Response to Issues – Department of Planning and Environment

21 Honeysuckle Drive, Newcastle – SSD 8019

7.1 Views From The Sun - Winter Solstice - 21/06/2017

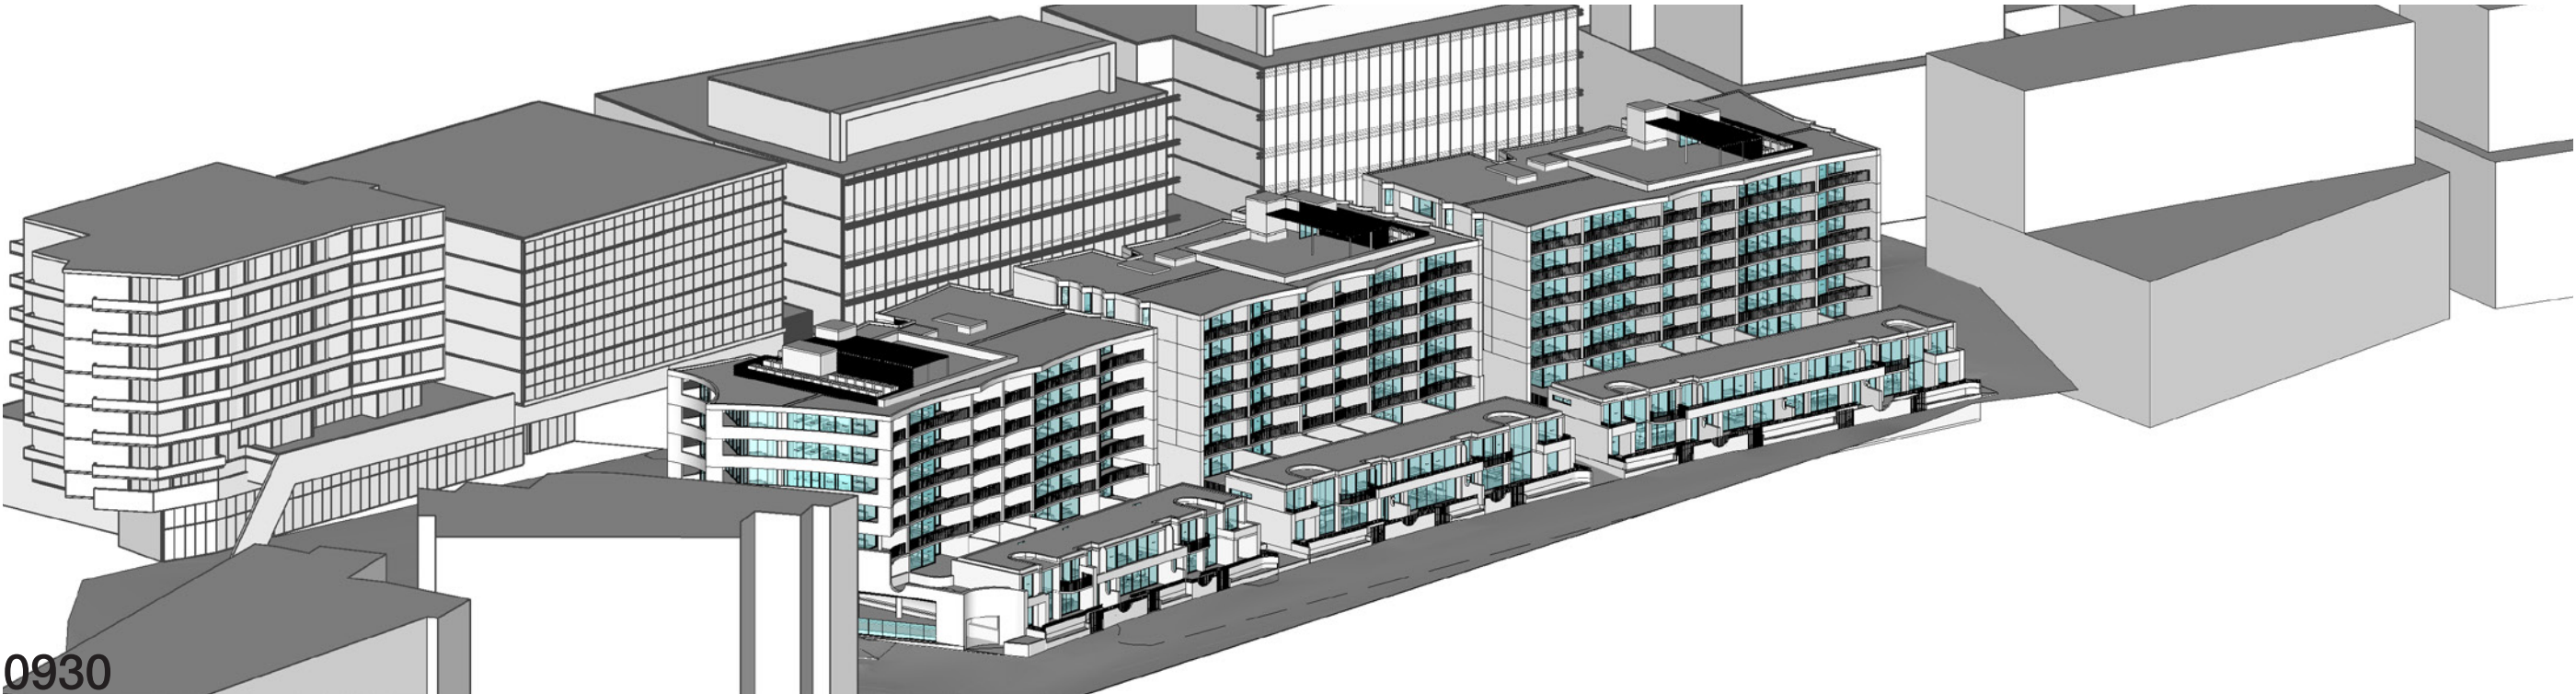
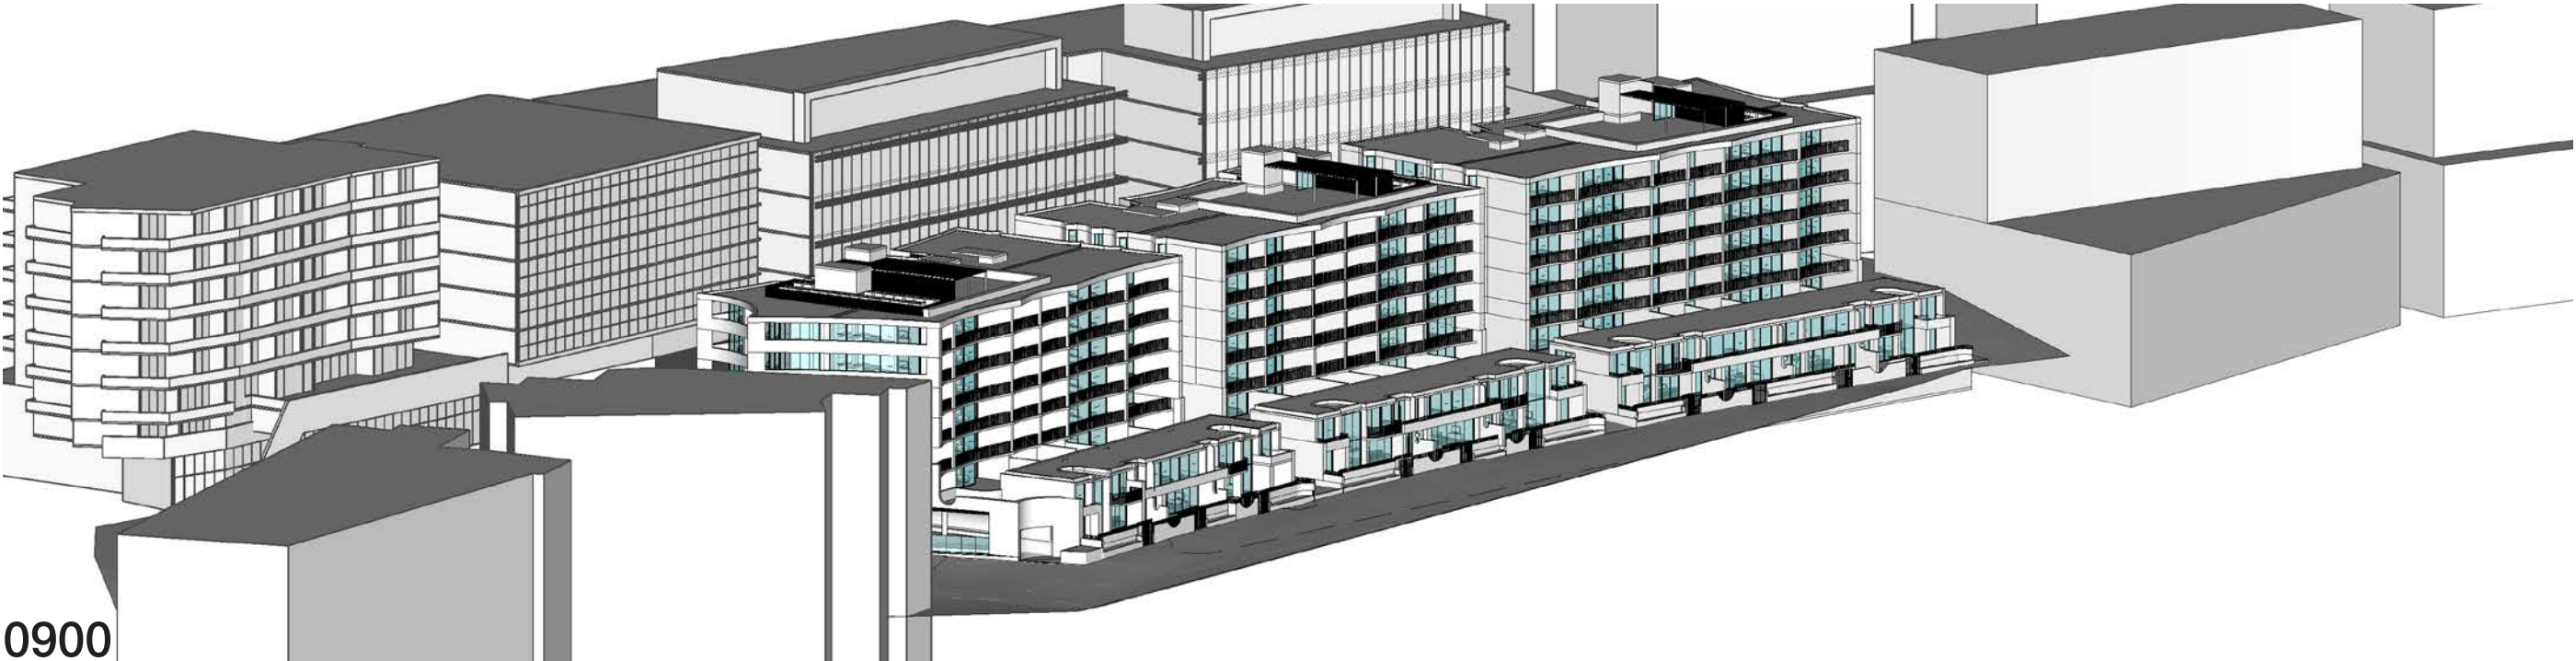
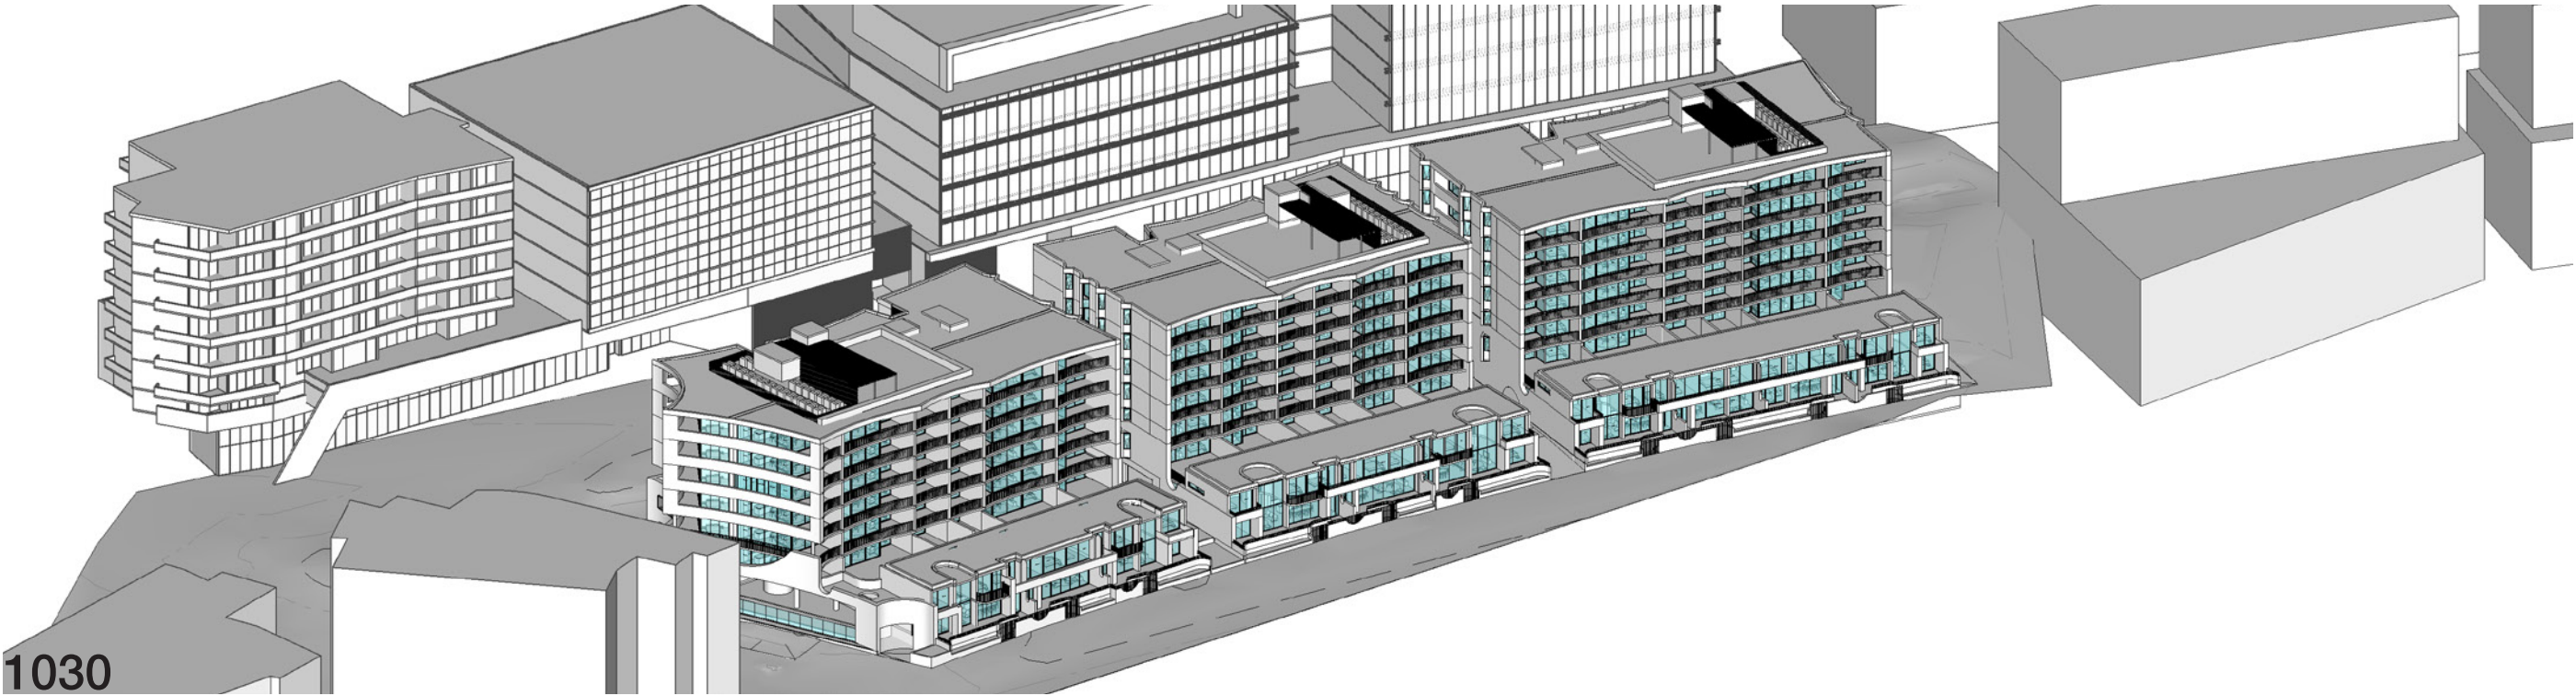
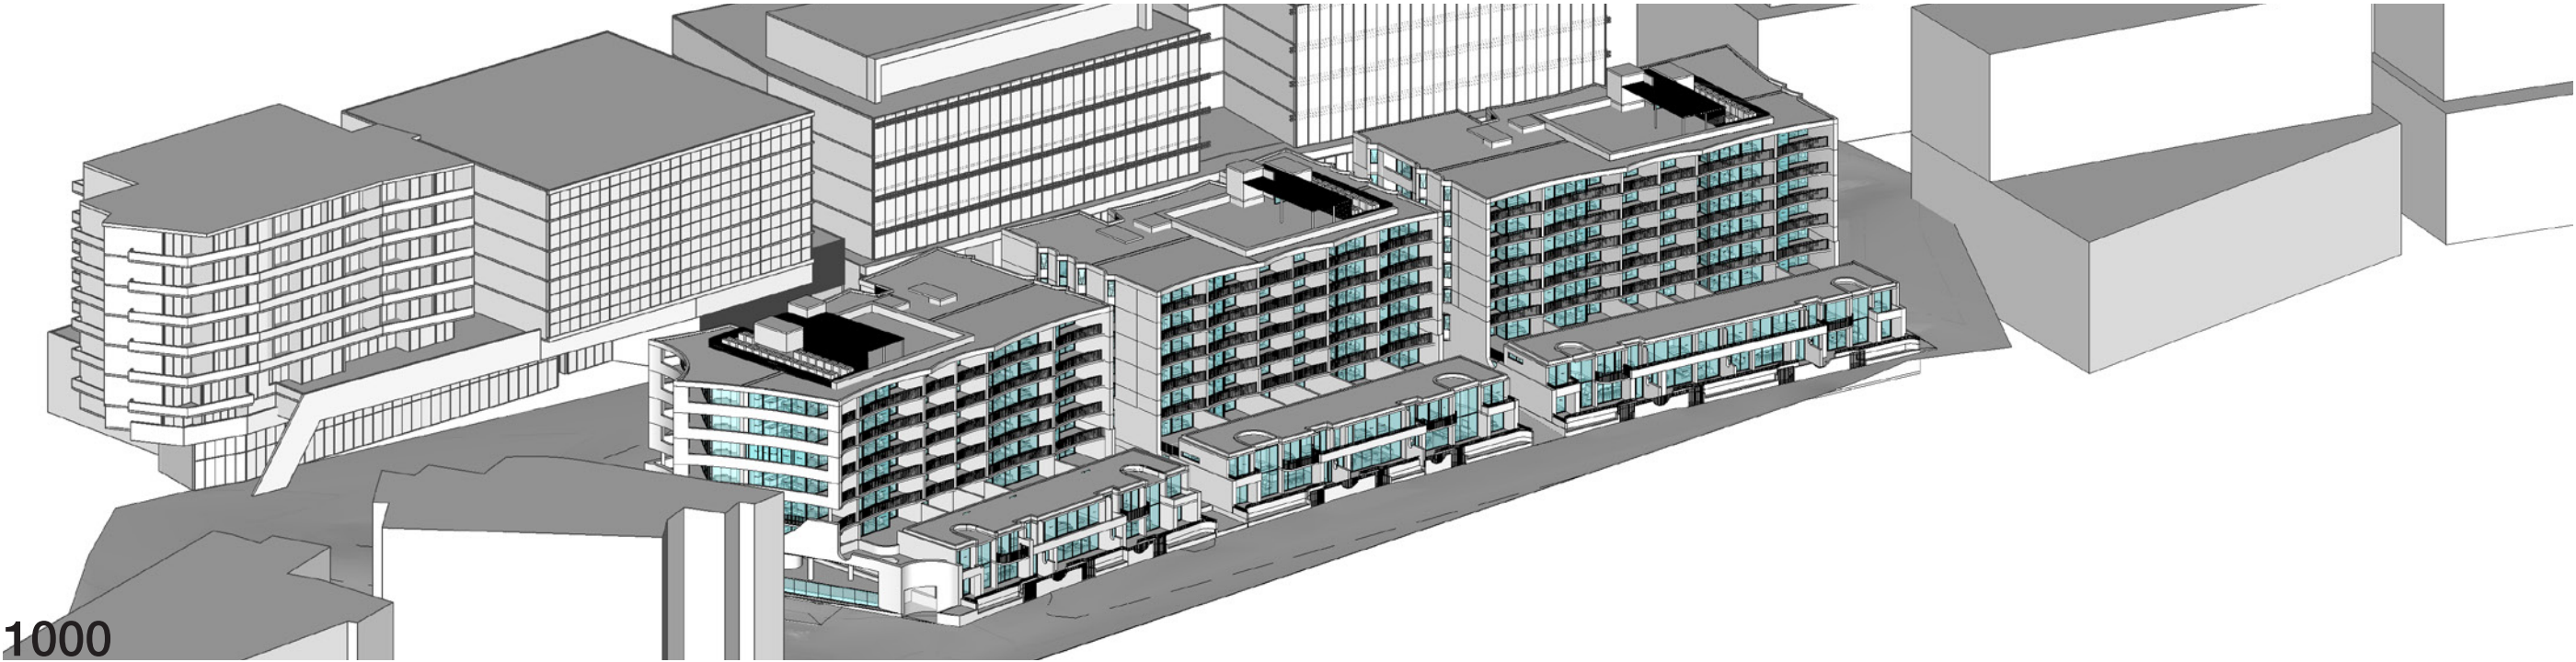
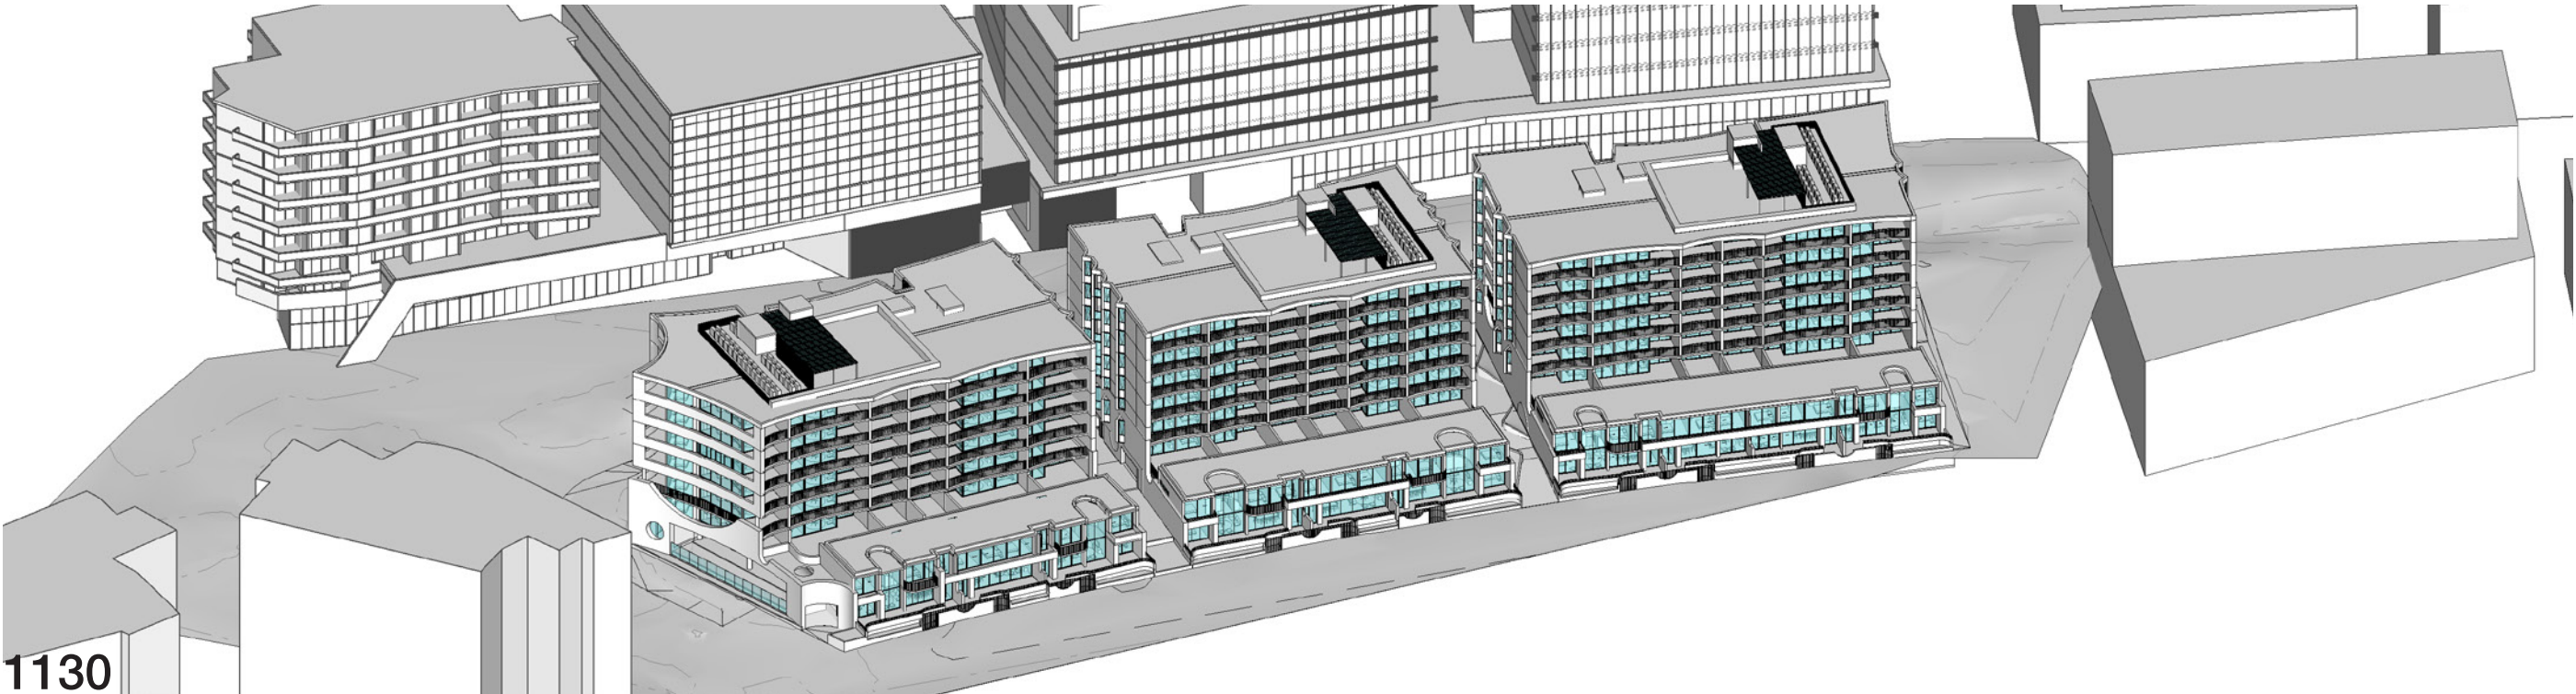
Particulars of Issues	Response	Attachment
<i>The overshadowing impacts of the proposal should be reviewed, including confirmation of overshadowing to the south between 1:00pm and 3:00pm, and that the apartments achieve a minimum of two (2) hours solar access in midwinter. In particular, assessment should detail solar access to apartments at Level 1, having regard to all structures in their proximity, including balcony overhangs, and the location of the terraces to the north.</i>	Updated view from sun and shadow diagrams in have been prepared by SJB Architecture, confirming that 75.3% of apartments receive a minimum of two (2) hours solar access.	Refer to: <ul style="list-style-type: none"> Attachment 1: Revised Architectural Drawing Package; and Attachment 2: Built Form Analysis.
Noise		
<p><i>A supplementary acoustic assessment should be provided addressing:</i></p> <ul style="list-style-type: none"> <i>The potential design options to achieve nominated noise criteria should be provided, including façade design, opening sizes, room volumes and finishes;</i> <i>Potential treatments to mitigate noise impacts from mechanical plant and equipment;</i> <i>Potential mitigation measures for construction noise and vibration impacts to be incorporated into the construction program</i> <i>The impact of noise from Port activities on the proposed residential development, and any mitigation measures required to ensure satisfactory acoustic amenity for future residents.</i> 	An updated Acoustic Assessment undertaken by Renzo Tonin & Associates forms part of this resubmission. If required, additional acoustic information can be provided by way of condition.	Refer to: <ul style="list-style-type: none"> Attachment 6: Acoustic Report.
